RE: Planning Consultation for 8053/APP/2014/909

SITE: THE DE BURGH ARMS AND O J'S NIGHT CLUB, STATION APPROACH YIEWSLEY

PROPOSAL: Use of car park as a hand car wash

Dwg Name: PROPOSED HAND CAR WASH LAYOUT

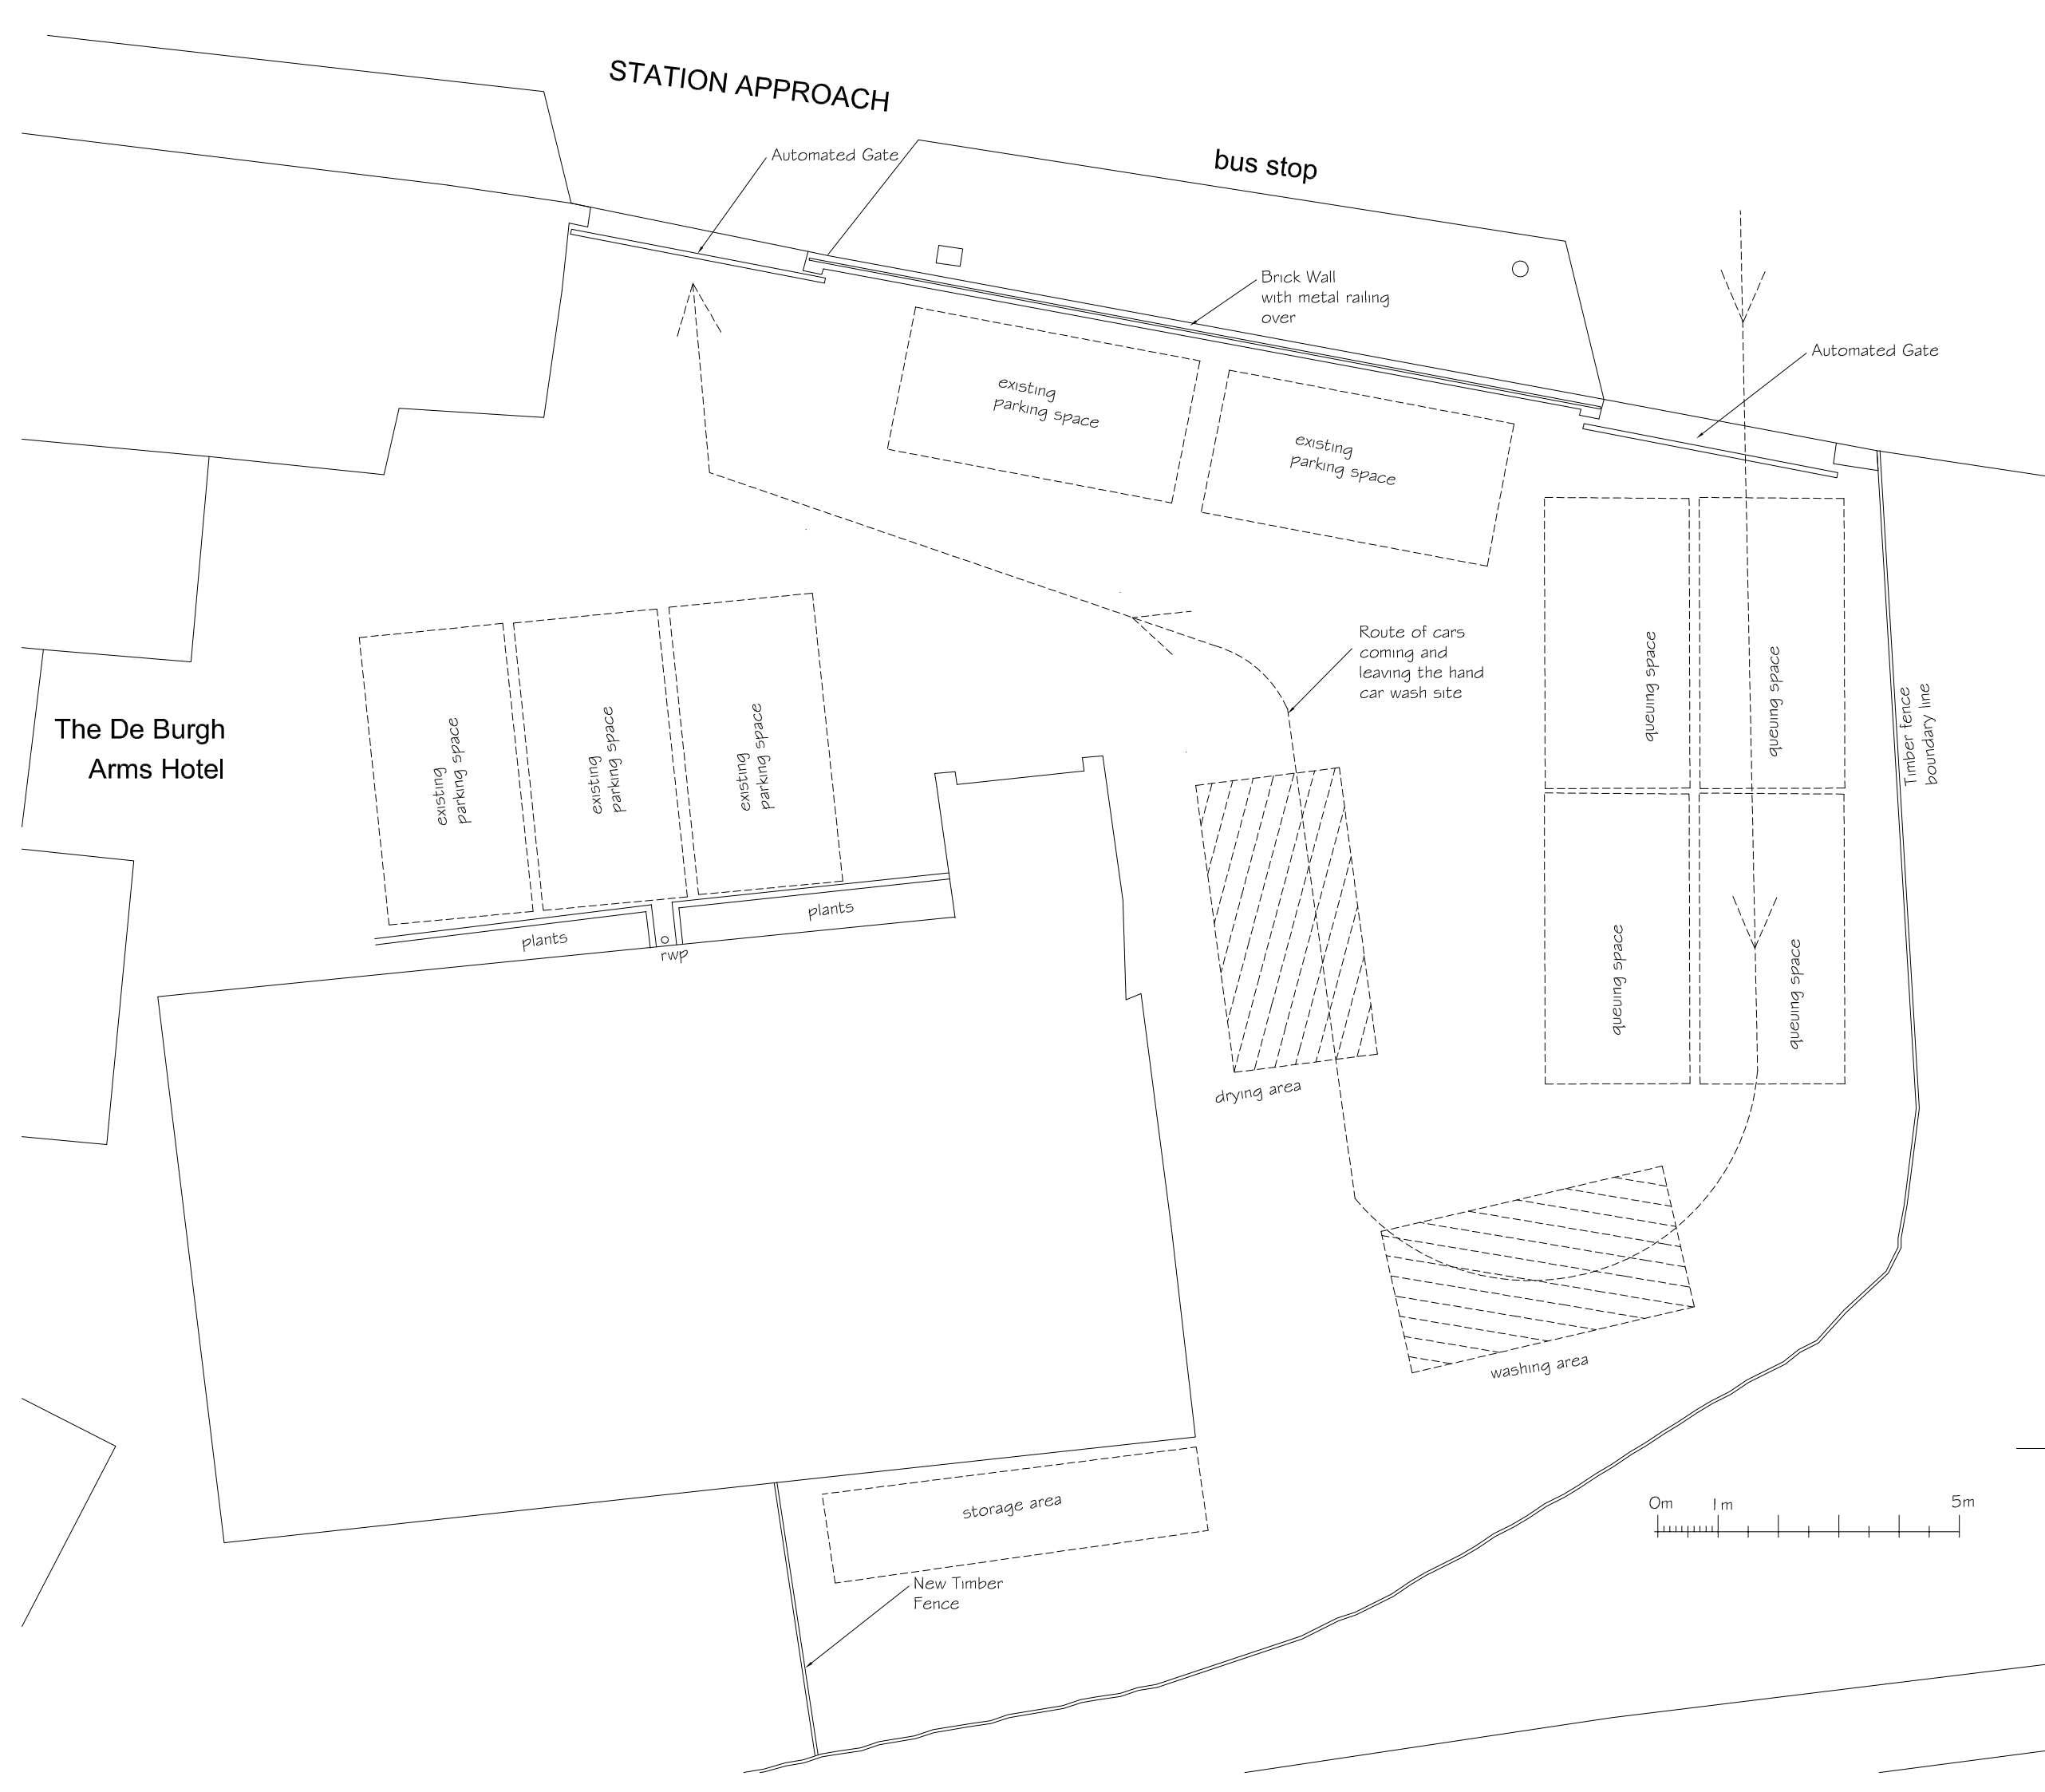
The applicant will need to confirm whether pressure washers are going to be used or not

High pressure washers (including jet washers) and steam cleaners are effective at removing dirt, grease and coatings from vehicles, machinery and surfaces. But they use large volumes of water (500 – 7,200 litres an hour), often at high temperatures and containing cleaning chemicals. If you are cleaning vehicles and plant with a high pressure washer (jet wash) or steam cleaner, you must use a designated washing bay.

If you use a pressure washer to clean roads, yard surfaces, and other equipment or in areas where the drainage isn't collected or connected to the foul sewer, you must stop run-off from entering surface water drains. See section 3 for good practice advice for dealing with this runoff. Never allow run-off containing cleaning chemicals, detergents or emulsifiers to enter surface water drains as this will cause pollution and prevent oil separators from working properly: see reference 9 for more information.

Further to the emails below I confirm that the applicant will use jet washers.

I enclose the drainage layout to show our intention in how to collect the water from the washing bay and discharging to foul drainage.
